From: Laura Gibbons <Laura.Gibbons@arun.gov.uk>
Sent: 01 March 2022 11:46
To: Planning.Responses <Planning.Responses@arun.gov.uk>
Cc: Simon Davis <Simon.Davis@arun.gov.uk>
Subject: RE: Planning Consultation on: P/15/22/DOC

Engineers Comments Regarding Surface Water Drainage

Application No: P/15/22/DOC

Site Address: Land adjacent to Sefter School House Sefter Road Bognor Regis PO21 3EE

Catchment Areas

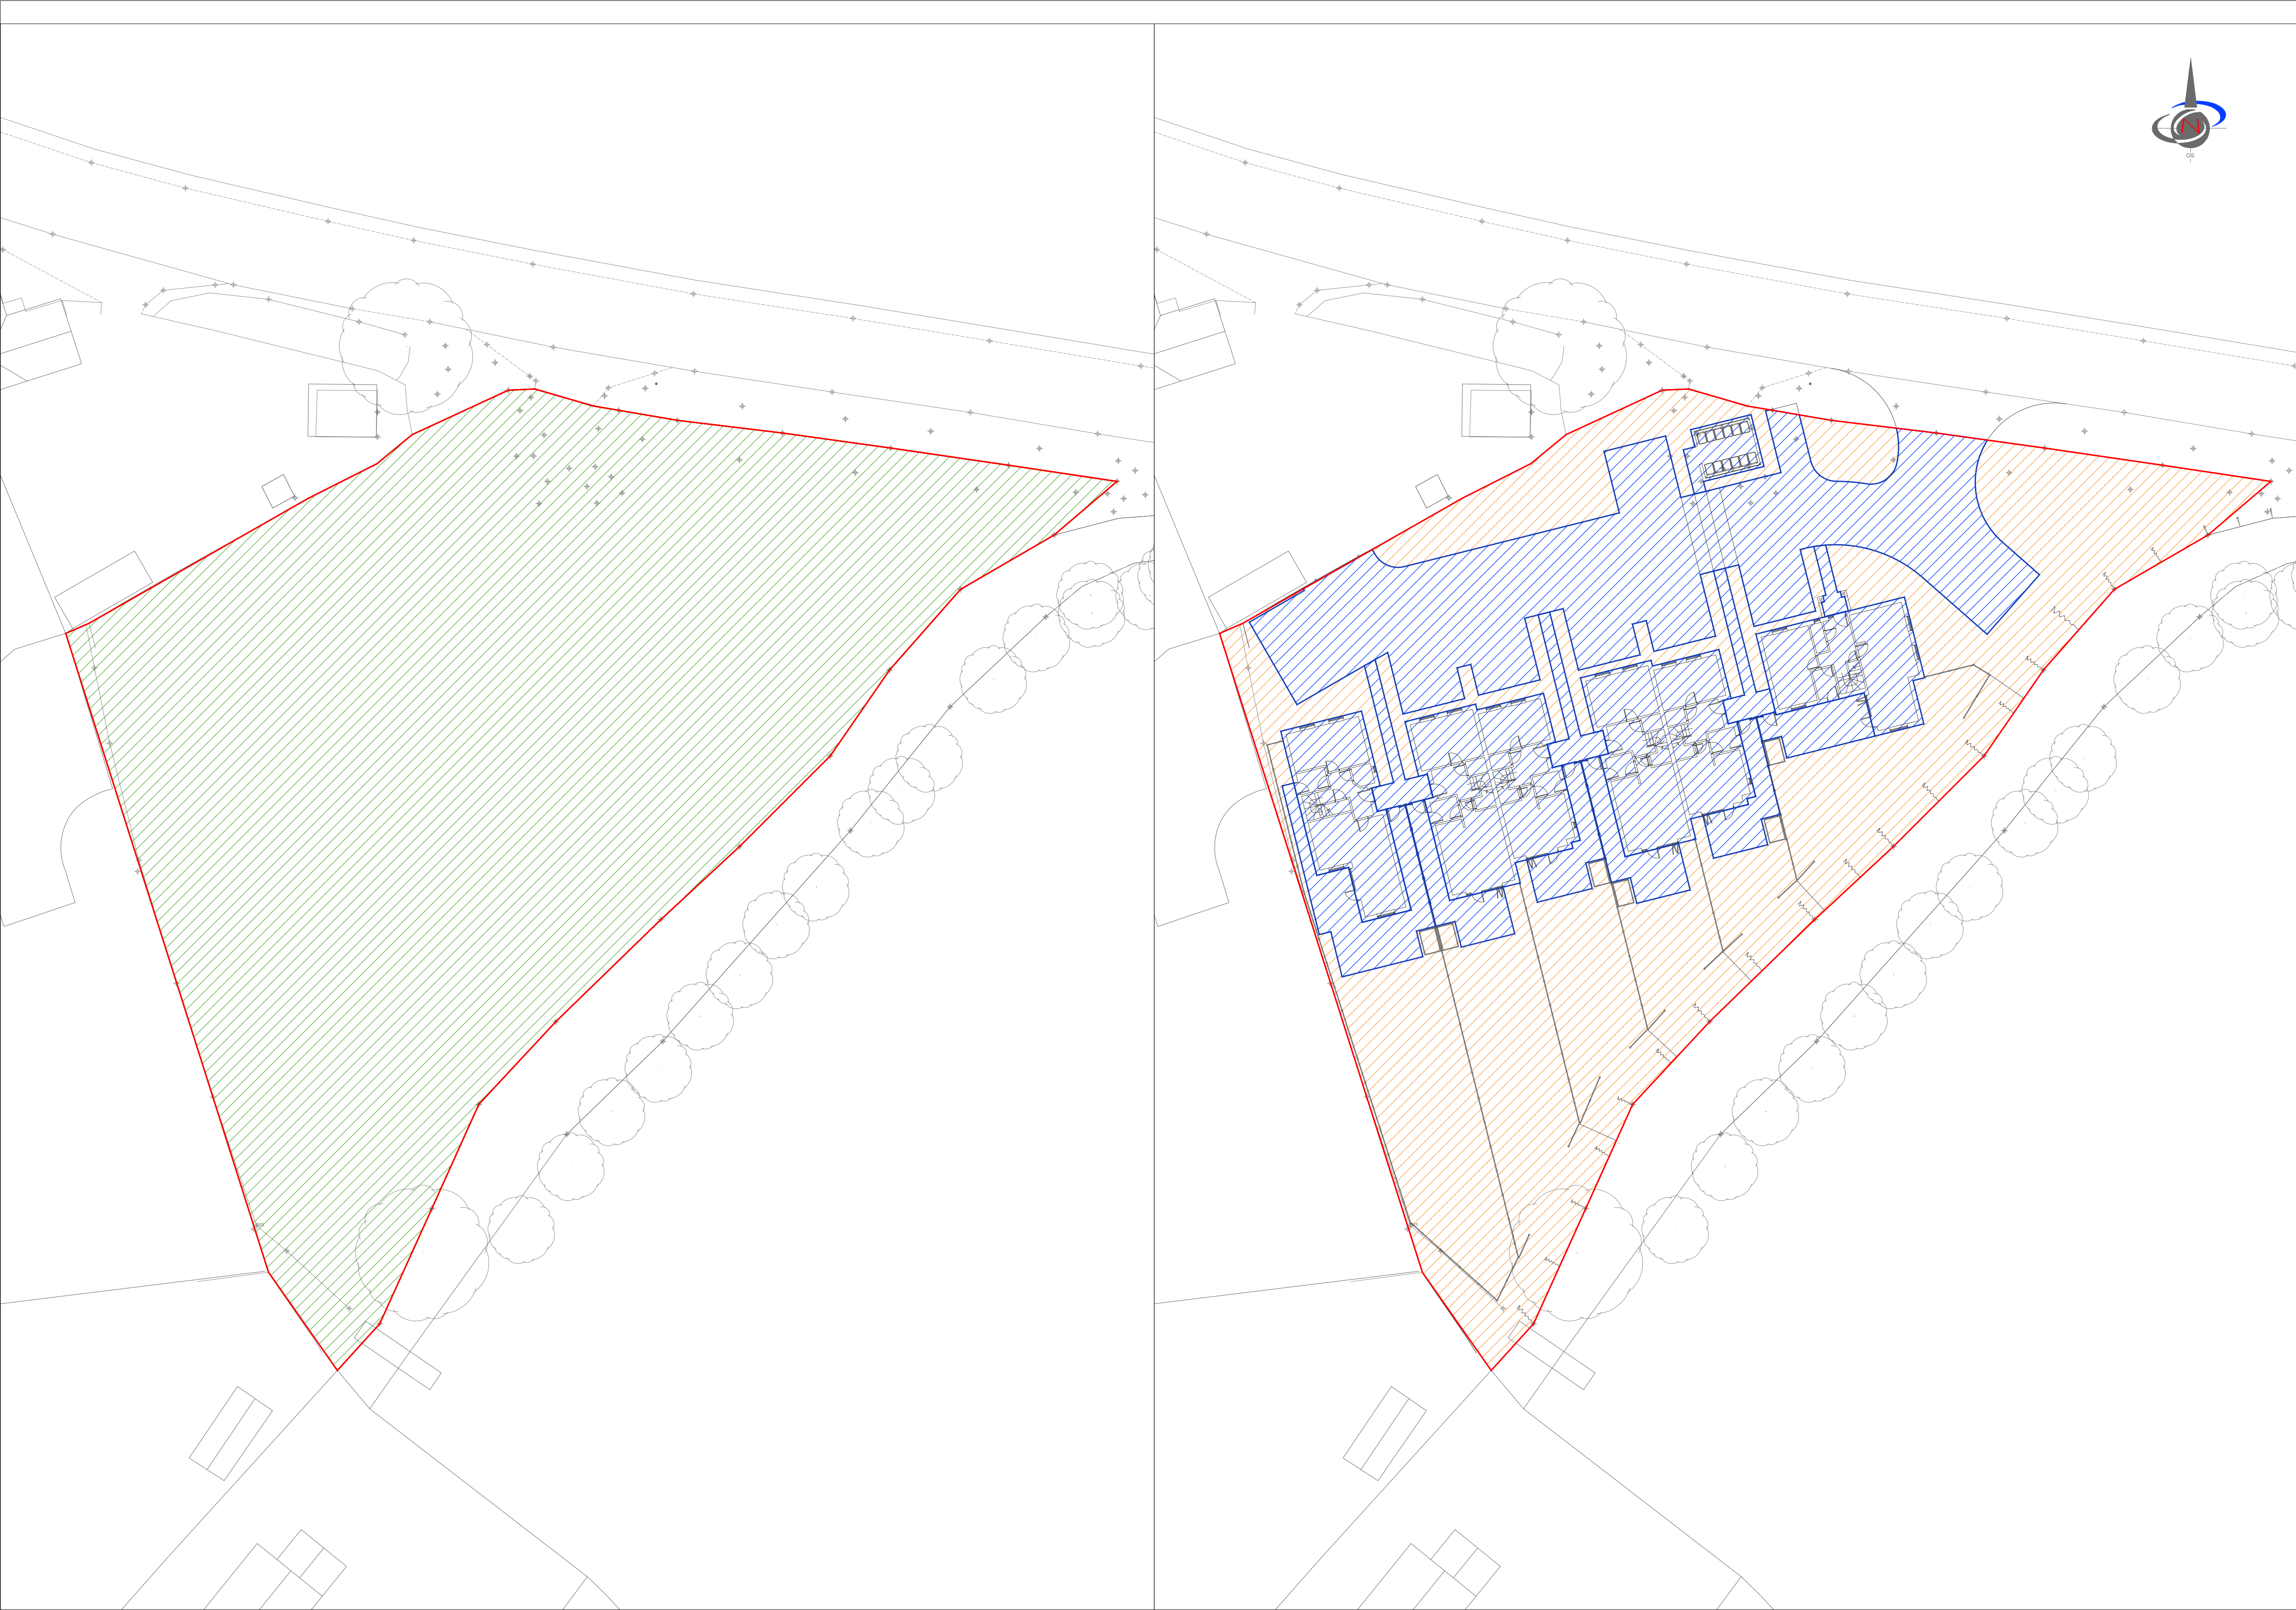
8. The proposed invert levels of outfalls are not clear (please clearly define them on plan), however upstream manhole inverts show that outfalls will not meet our minimum requirement for clearance between bed level and invert level of outfall pipes. As an absolute minimum we require 150mm.

9. Finish and formation level of permeable paving must be labelled on layout plan.
10. All pipes must be labelled with diameter and fall.
11. Please label gully cover levels on plan.

12. Hydrobrake unit reference must be stated on plan.
13. Please show connections from permeable paving areas to the piped network.
14. Exceedance flow plan has been cropped, please supply the full plan.
